A585 Windy Harbour to Skippool Improvement Scheme

TR010035

7.11 Environmental Statement Changes and Corrections Document

July 2019

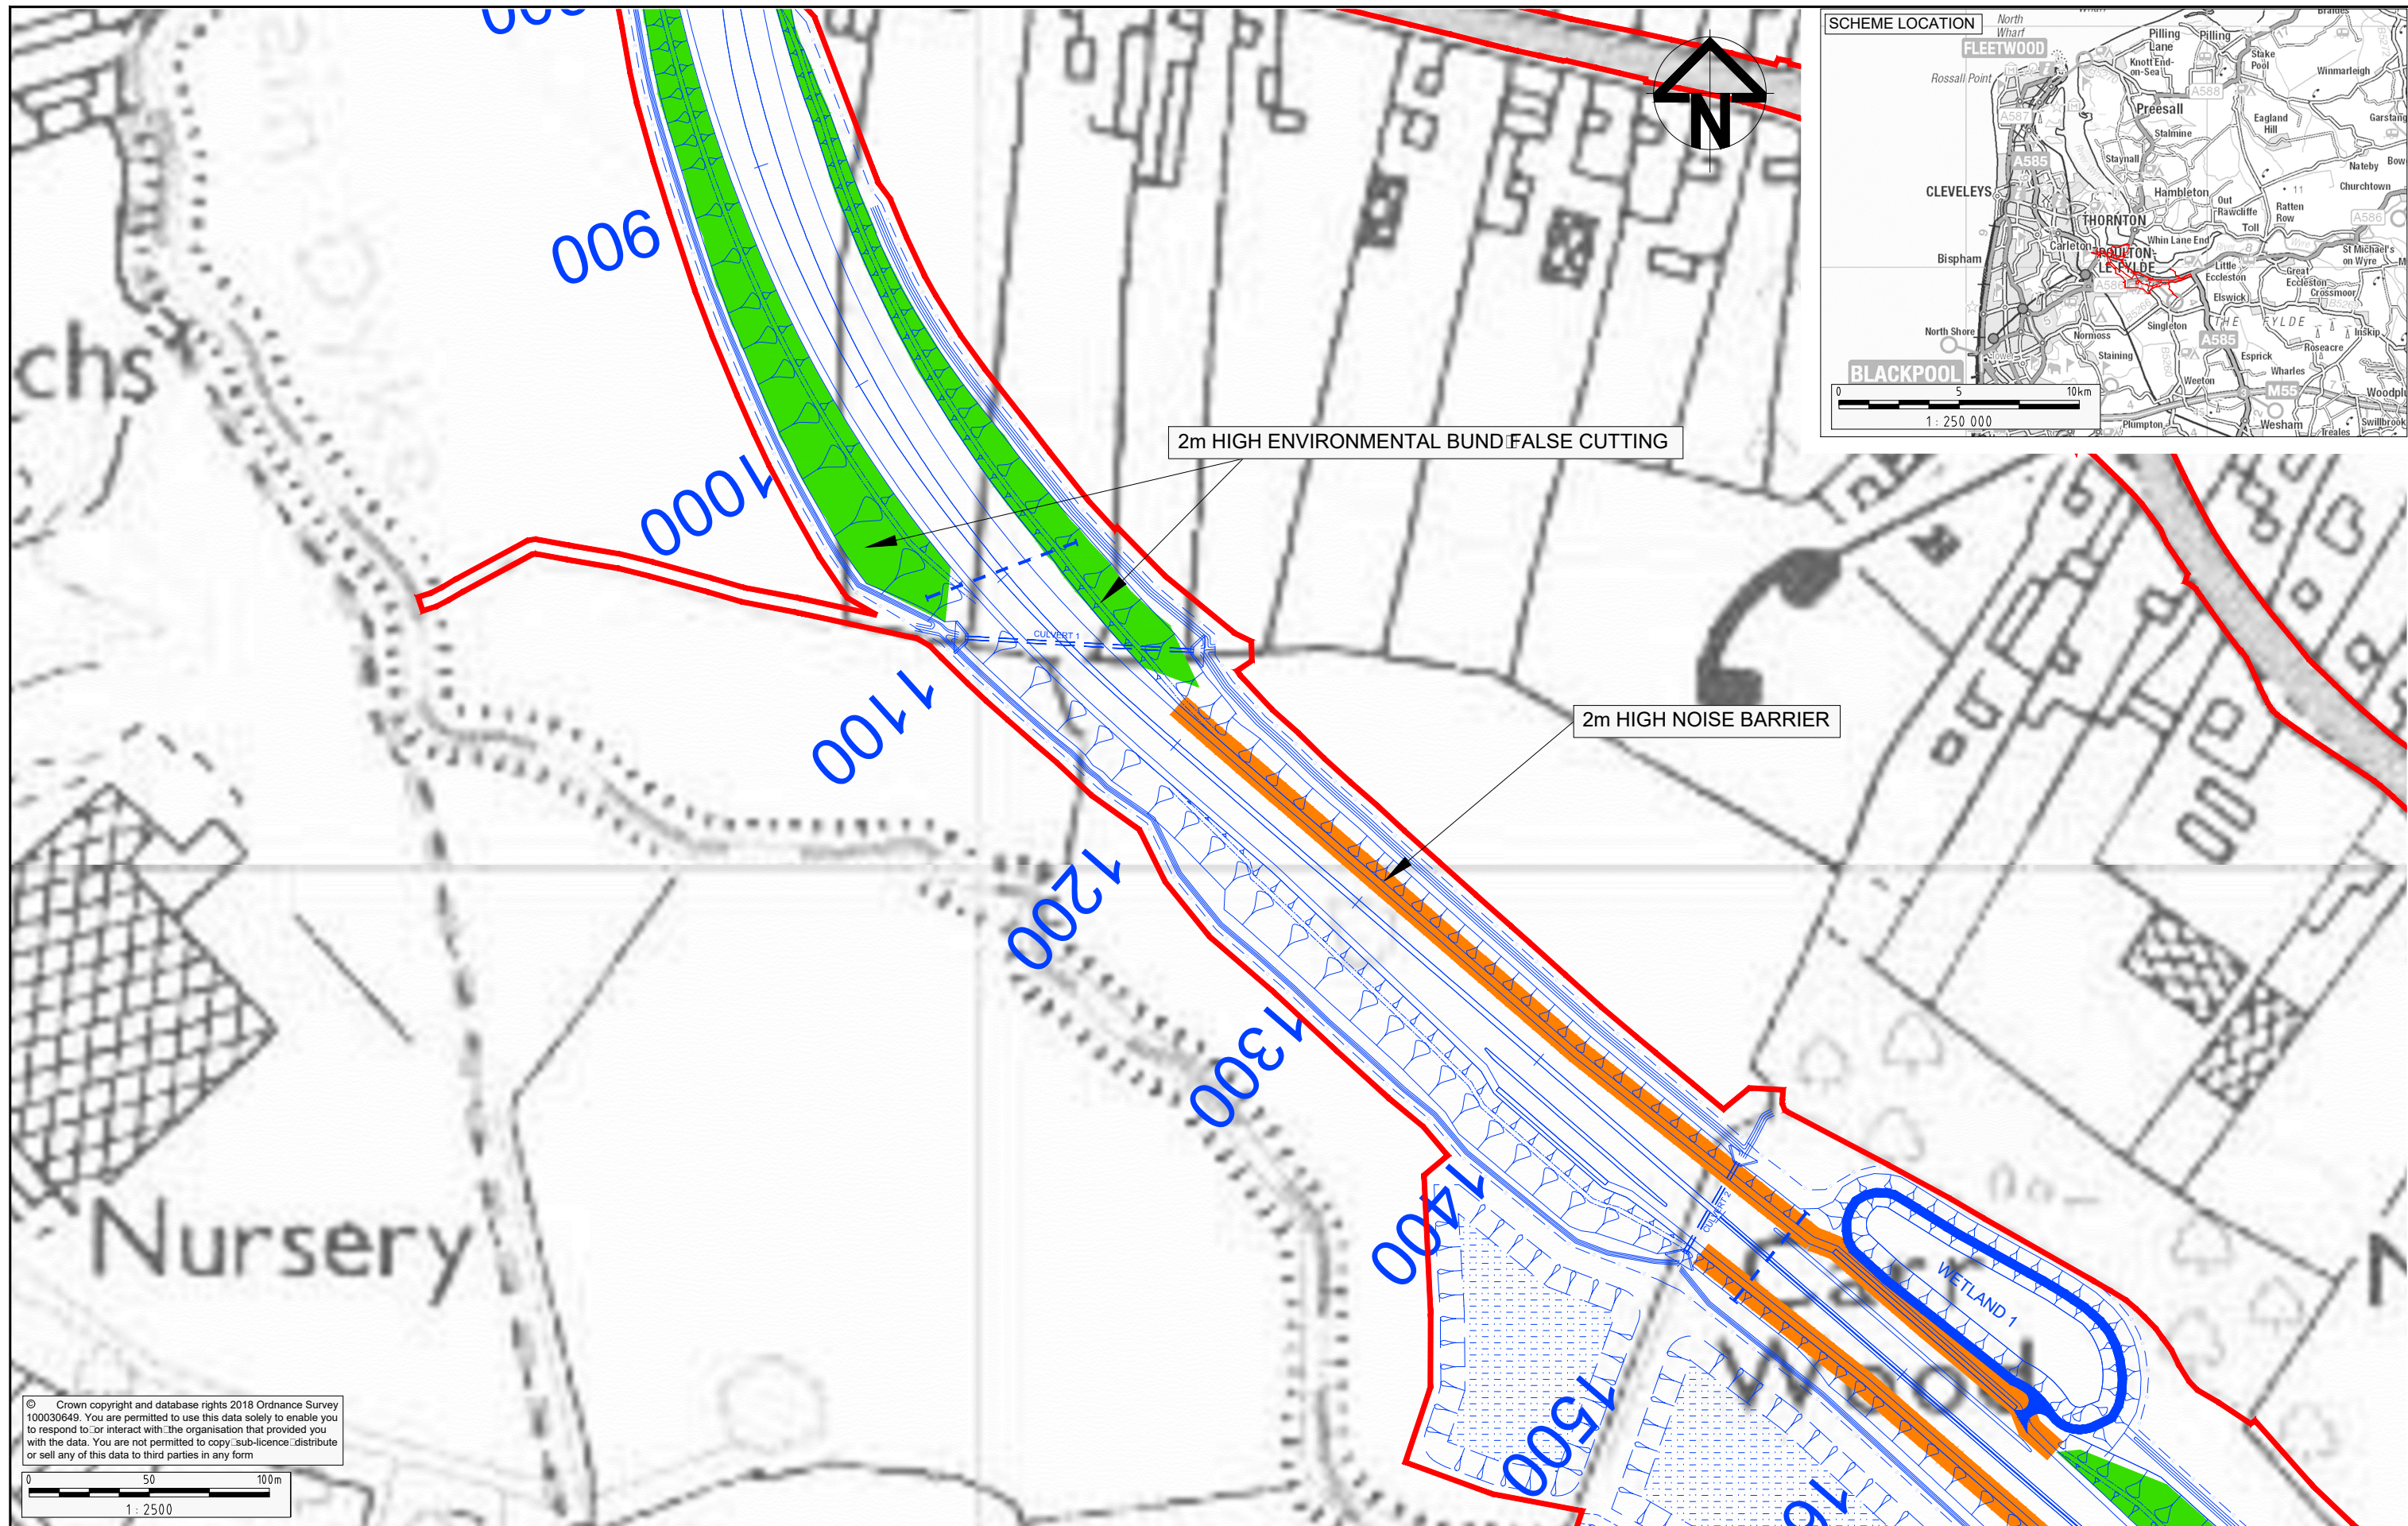
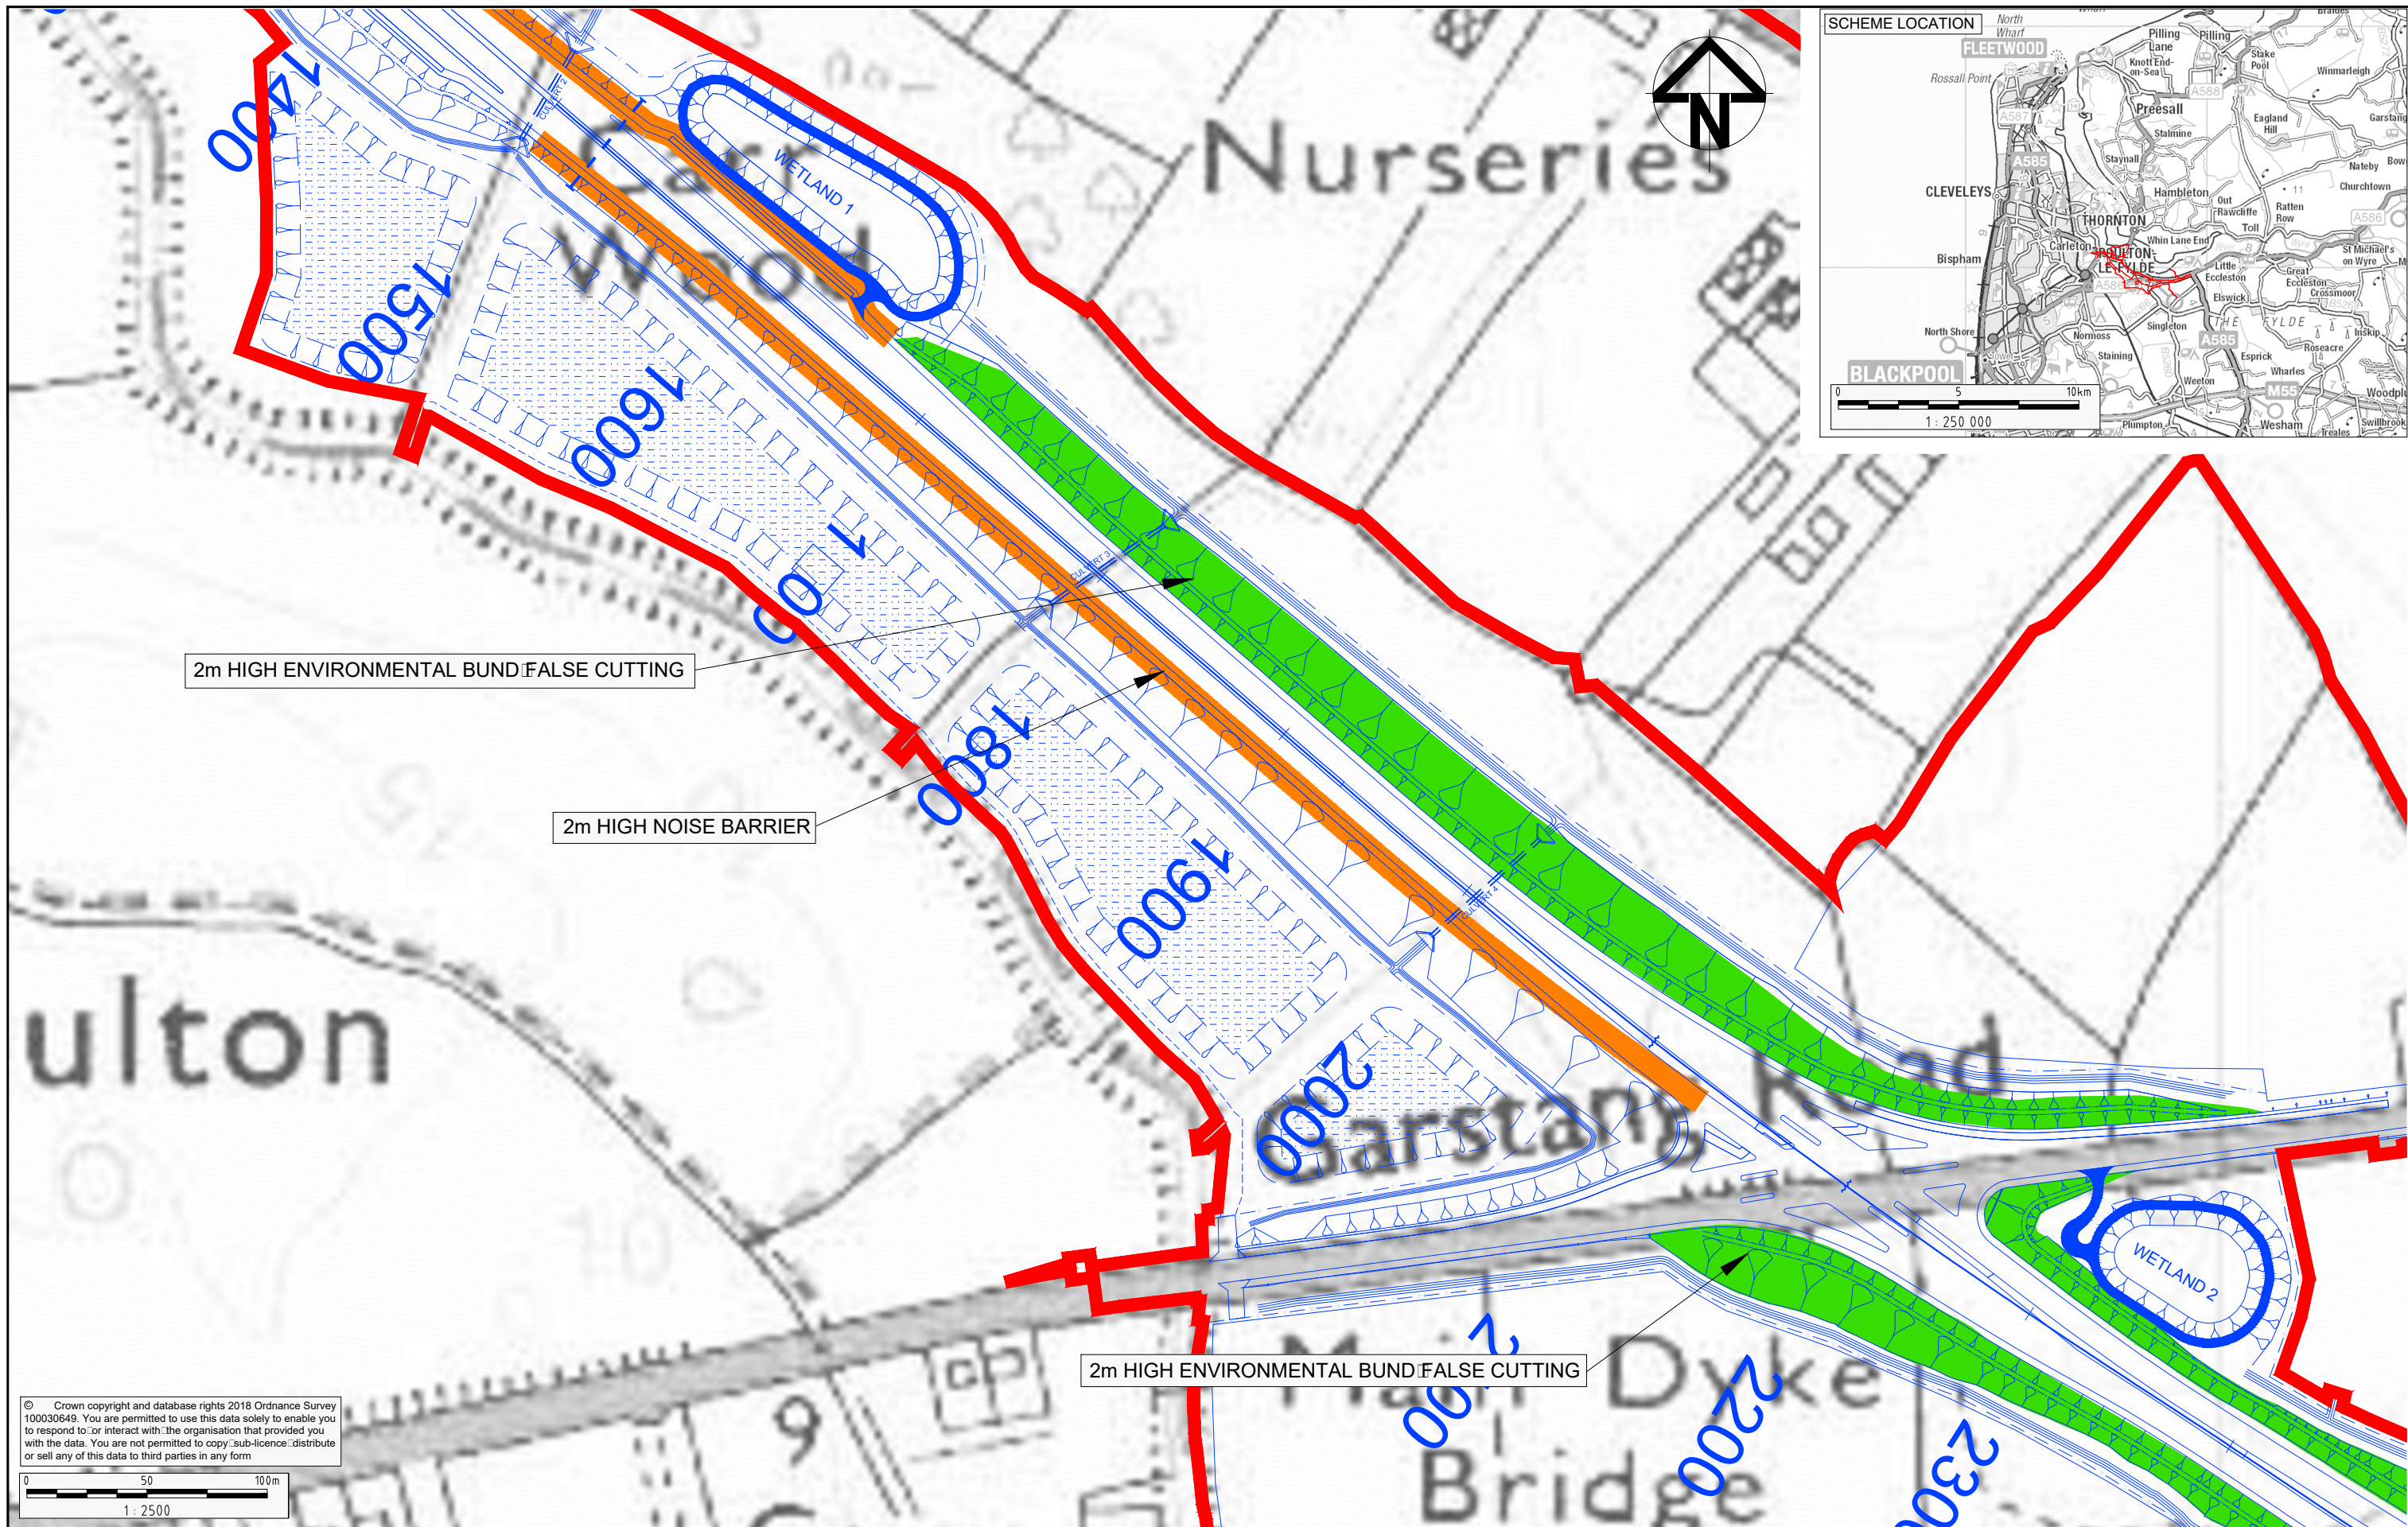
Document Reference Number	Document Name	Amendment Required	Reason
			TR010035/APP/7.10).
6.11	ES Chapter 11: Noise and Vibration	Update to Figure 11.4: Noise and Vibration – Noise Mitigation within the Study Area presented at Appendix D to show heights and locations of earth mounds and acoustic fencing at a larger scale.	Requested by the Inspector within the first round of written questions (document reference TR010035/APP/7.10).
